EL PASO COUNTY STORMWATER MANAGEMENT PLAN CHECKLIST

EPC Project Number: **CDR241**

**WELL NO. 22 TRANSMISSION LINE PLAN**

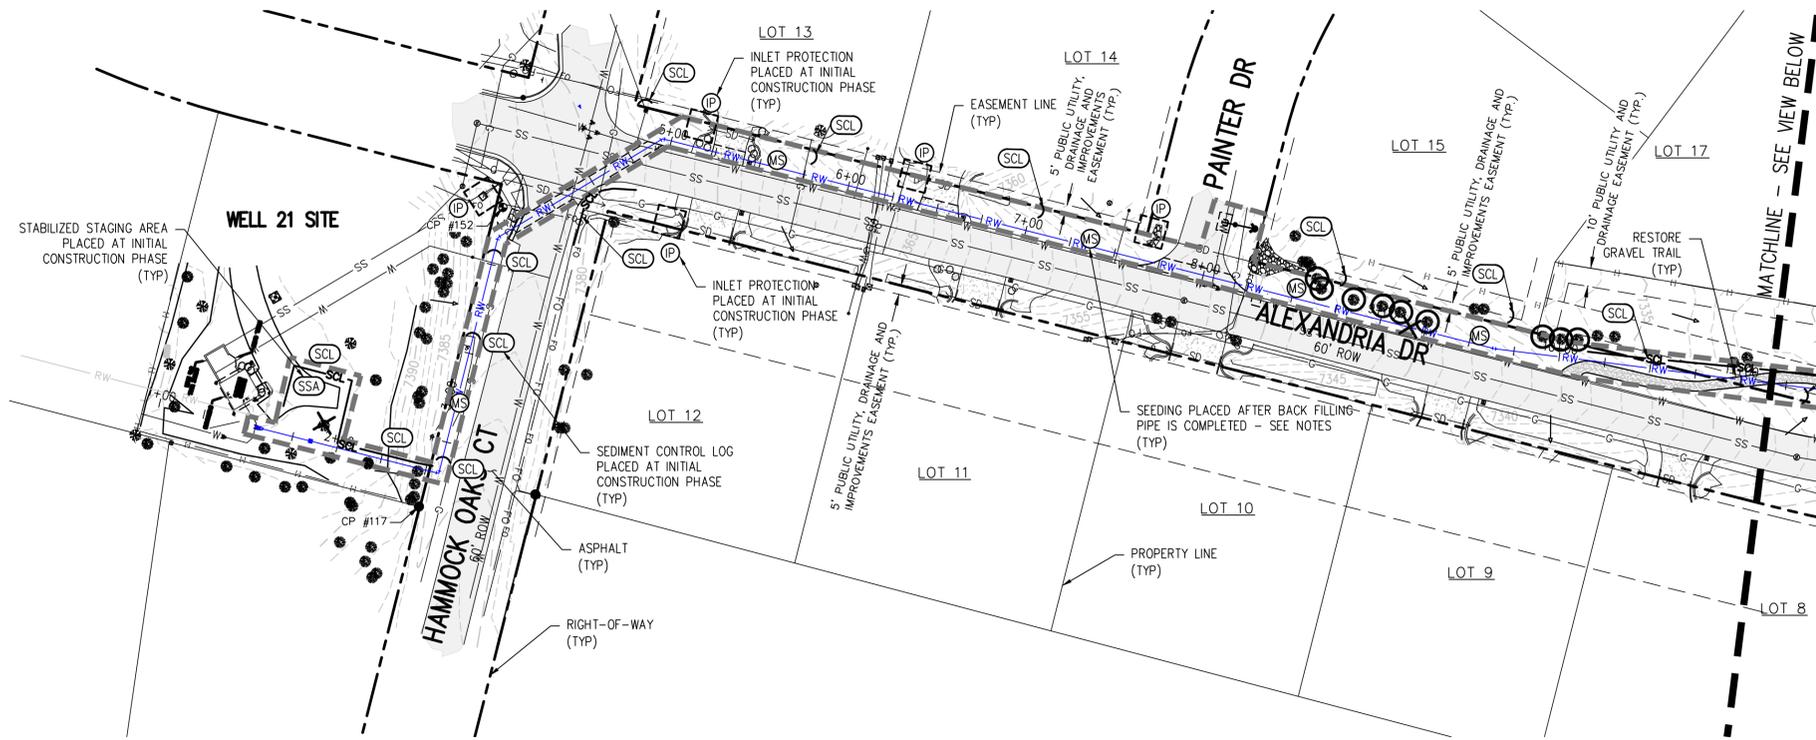
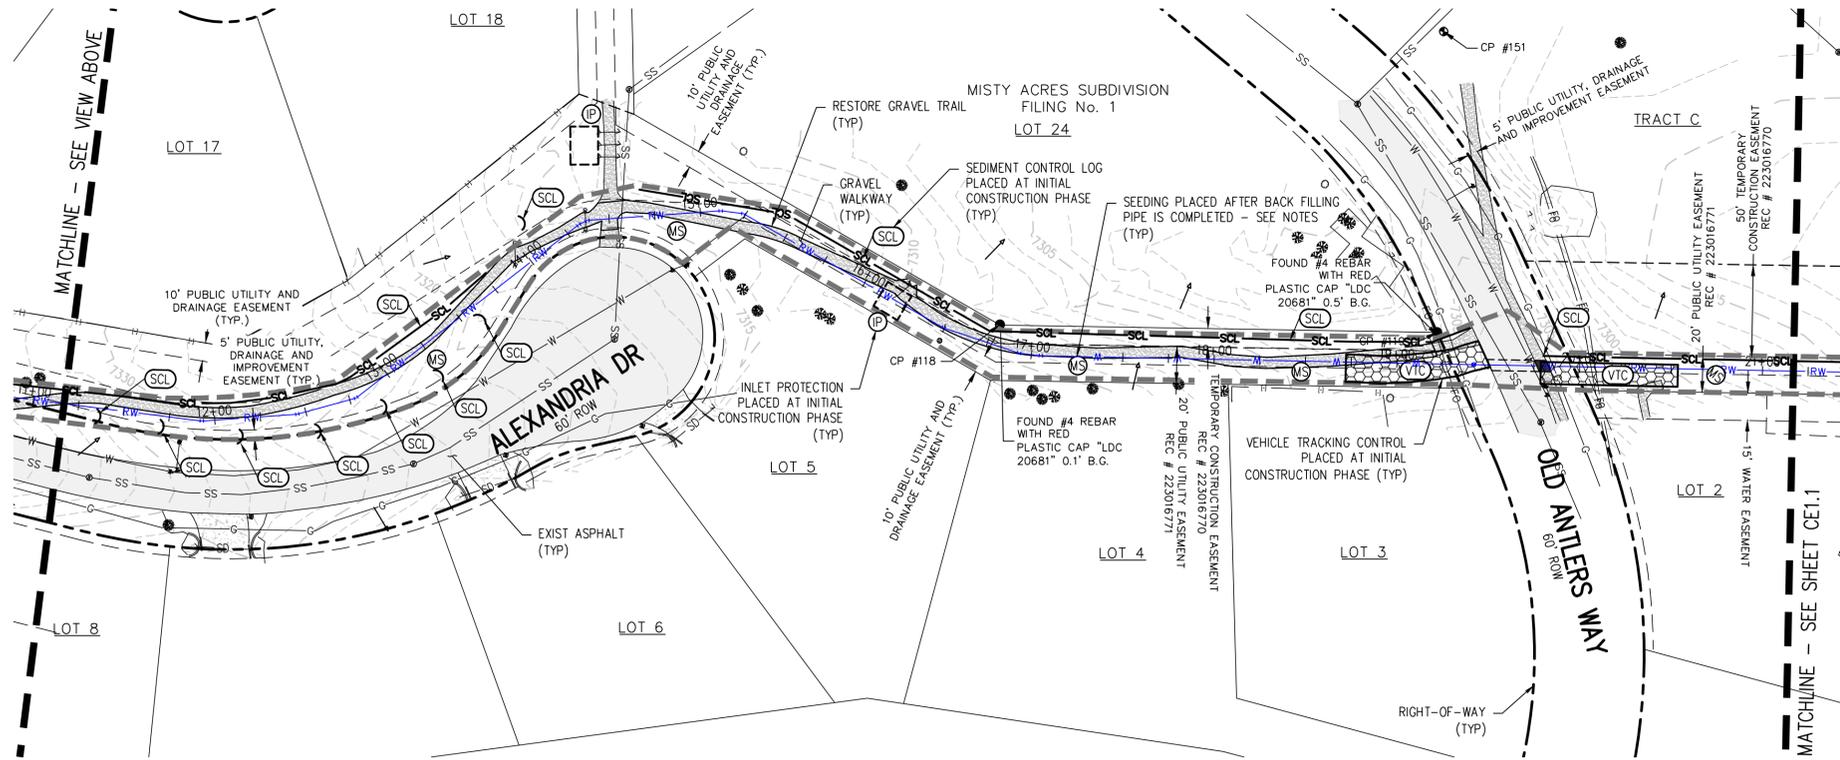
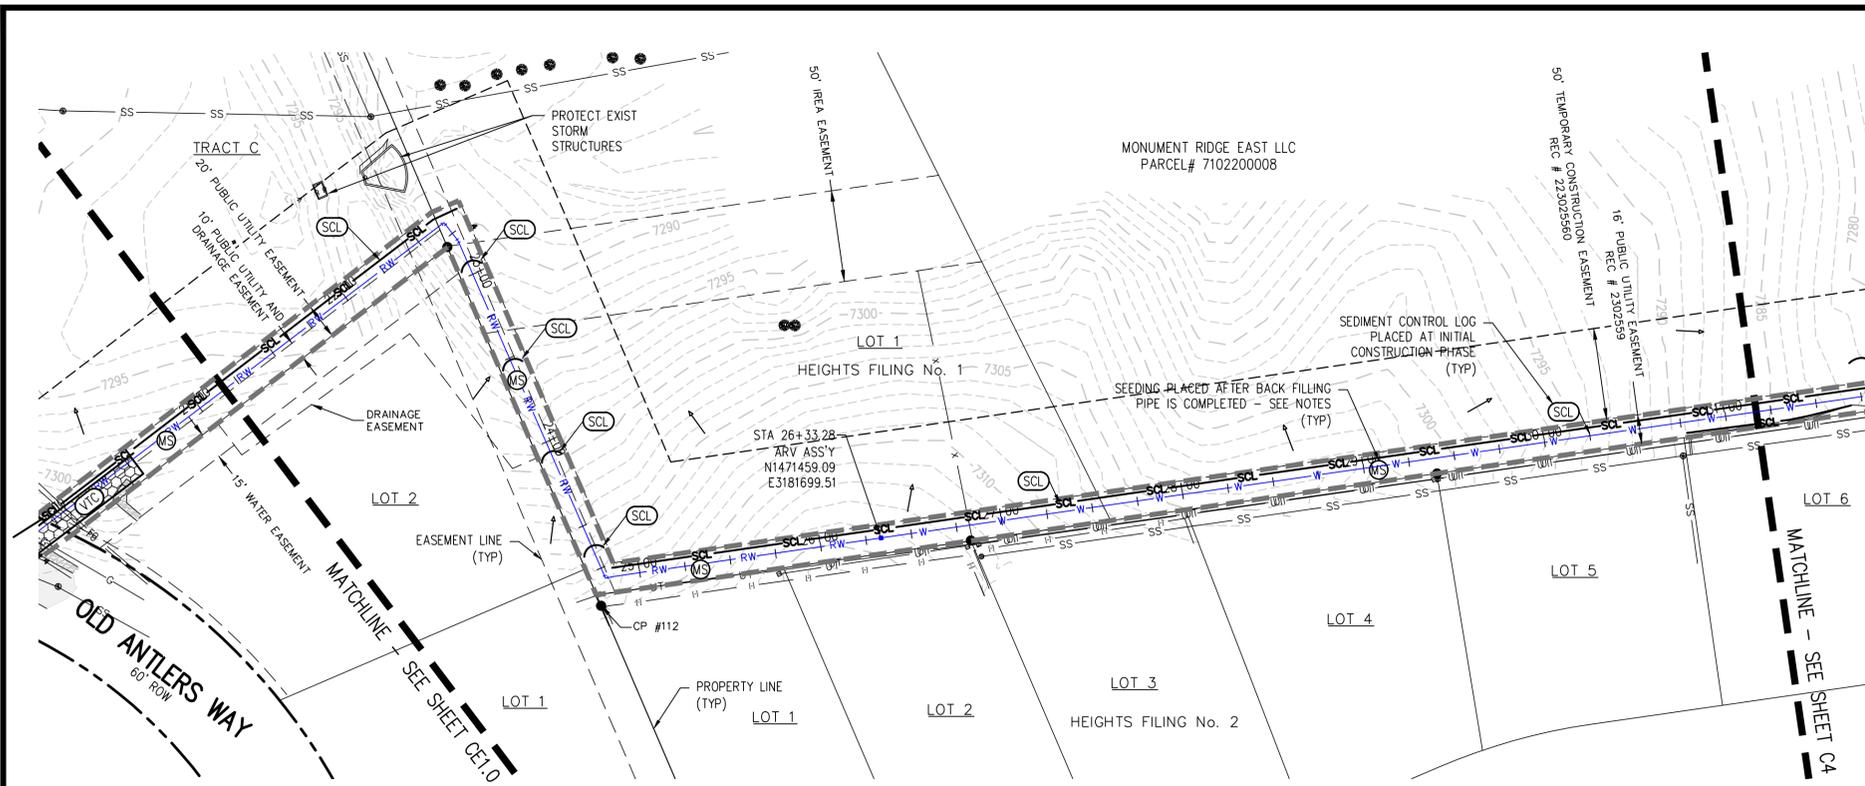
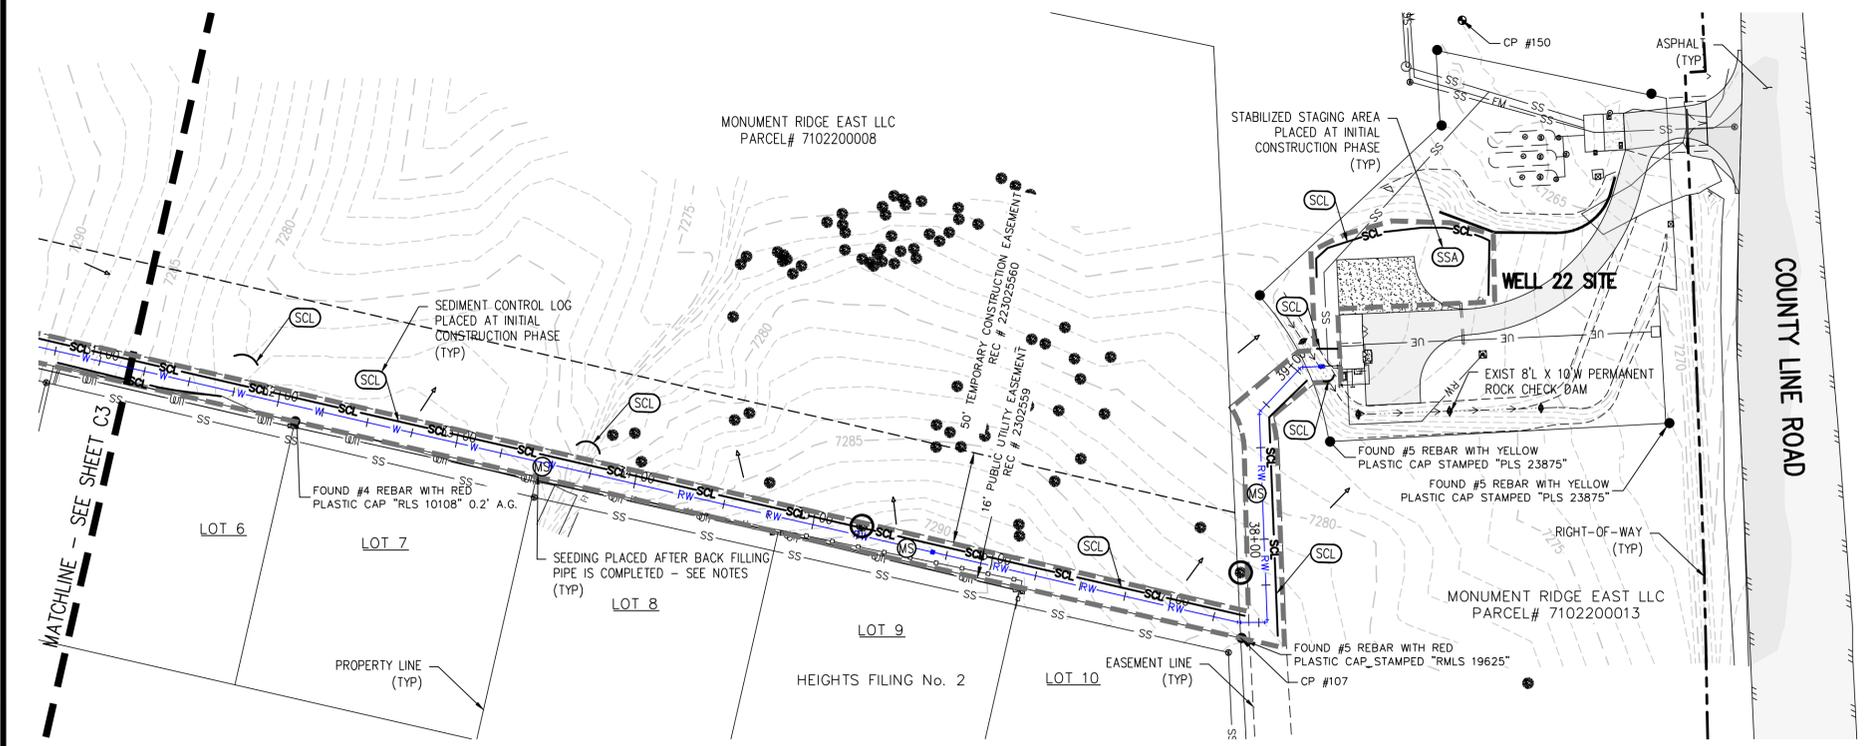
Your callouts for each BMP on Shts CE1.0 and CE1.1 state which phase the BMP should be installed in.
